## JUSTIFICATION DOCUMENT.

NEWGATE GARAGE, NEWGATE, MIRFIELD, WEST YORKSHIRE, WF14 8DB,  
UNITED KINGDOM.

PROJECT TITLE NEWGATE GARAGE, MIRFIELD			
DRAWING TITLE BLOCK PLAN			
SCALE	DRAWN	CHECKED	PROJECT REFERENCE
1:500	EC	JH	ODS_21-499
PAPER SIZE	DWG NUMBER	DATE	REVISION
A3	(20)002	10/10/24	/
CLIENT MOHAMED ADEEL

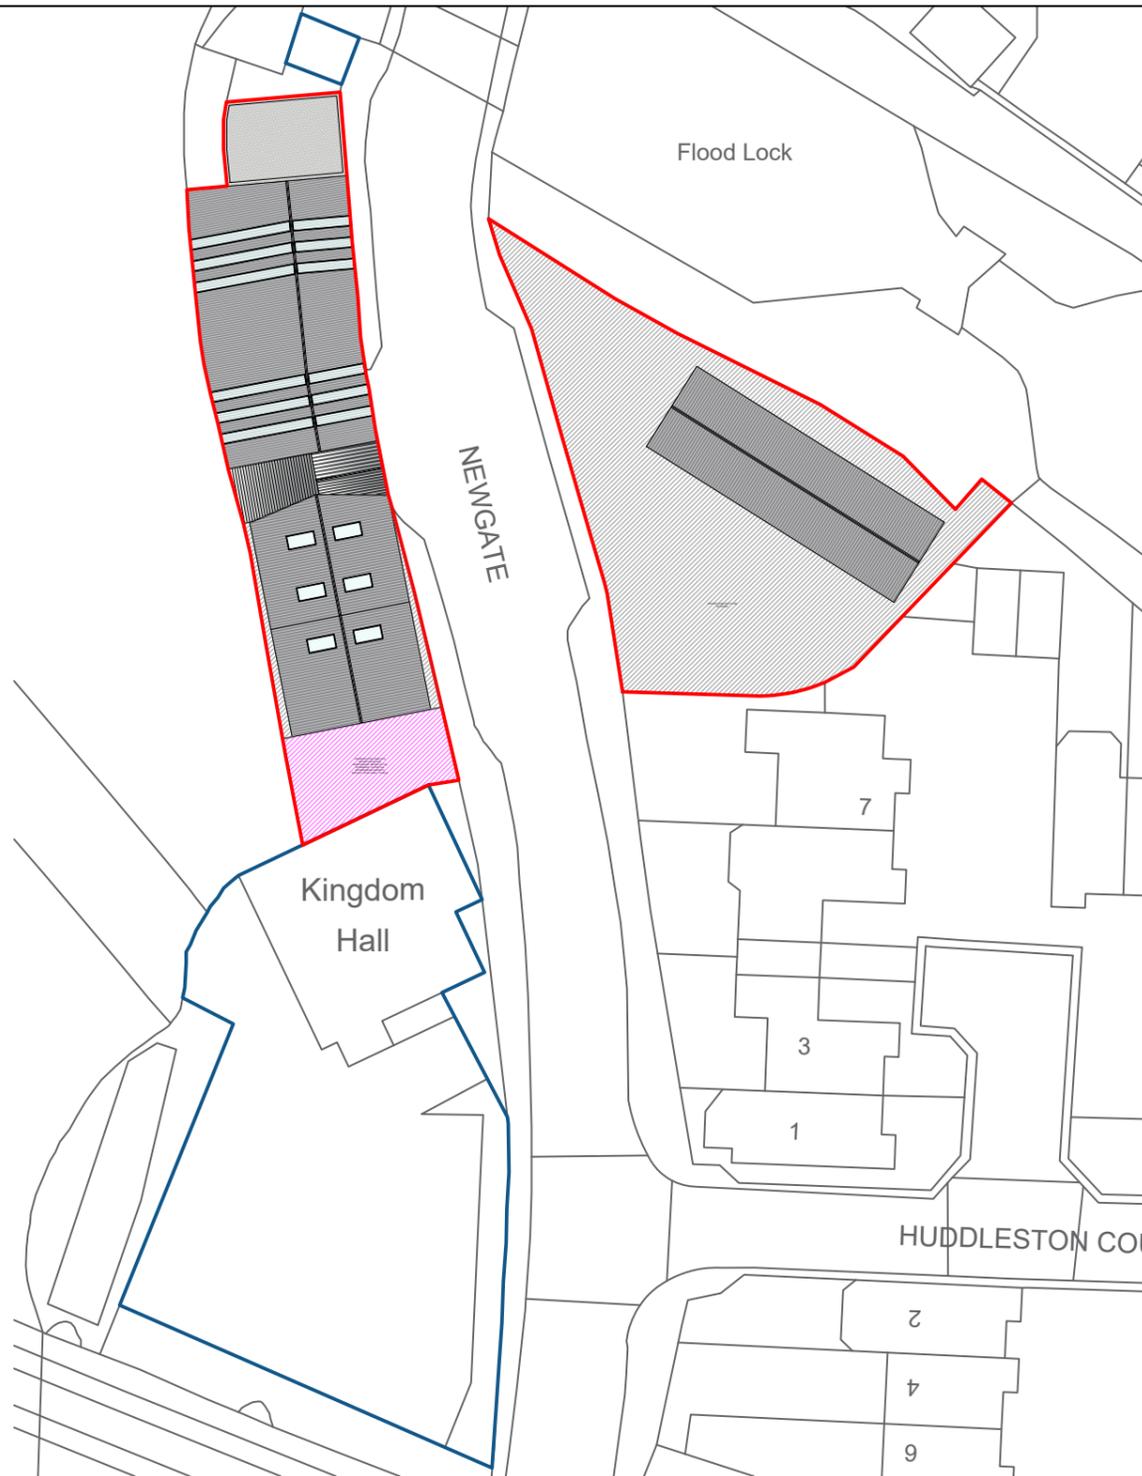
Following the Environment Agency's comments, we have revised the proposed scheme to ensure the development maintains a suitable unobstructed area for maintenance and improvement works to the riverbank. The overall width of the proposed extension has been reduced, creating an increased distance between Kingdom Hall and the proposed extension to the existing historic garage. This provides a clear and accessible area of land, located at the widest part of the riverbed, for future maintenance, emergency works, and inspection activities. This area of land is shown in dashed pink on drawing (20)002 Block Plan. This unobstructed plot of land has a total area of approximately 72 square meters. It measures about 5.26 meters wide at its narrowest point and 7.45 meters at its widest point.

| PAPER SIZE A1 | DWG NUMBER (30)001 | DATE 13/08/25 | REVISION / |

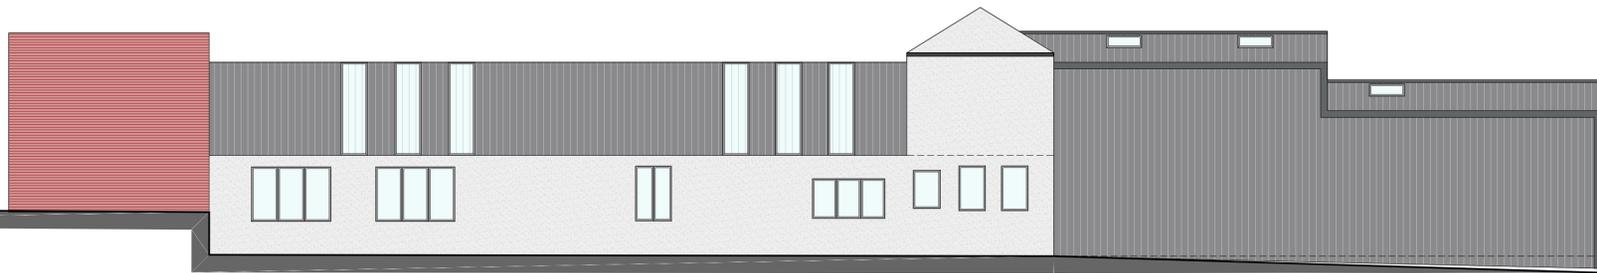
Following the planning officer's feedback, the scheme has been revised to ensure the roof design integrates more coherently with the existing building. The extension roof has been redesigned to adjoin directly with the existing roof, creating a continuous and unified appearance. This change removes the previous visual disconnect and ensures the extension reads as an integrated part of the host building rather than an incongruous addition. In response to the topography of the site, the roof has been staggered to step down in height. This design approach softens the buildings massing and follows the natural land levels, reducing the visual impact from key points. The EAVES height of the southern boundary has been set below the EAVES height of Kingdom Hall, in line with the officer's

request. The ridge level of the proposed extension is the same level as the EAVES of Kingdom Hall. This creates a more sympathetic, subservient relationship with the neighbouring building, helping the extension blend into the established street scene. In the area where the van servicing ramps are proposed, it is necessary to maintain sufficient roof height and EAVES level to allow adequate clearance when the vans are raised on the machinery. However, care has been taken to ensure that proposed EAVES level in this section is set lower than the existing EAVES levels on the gable-end element. This approach allows for the building to remain functional for its intended use while also reducing the overall visual impact of the extension.
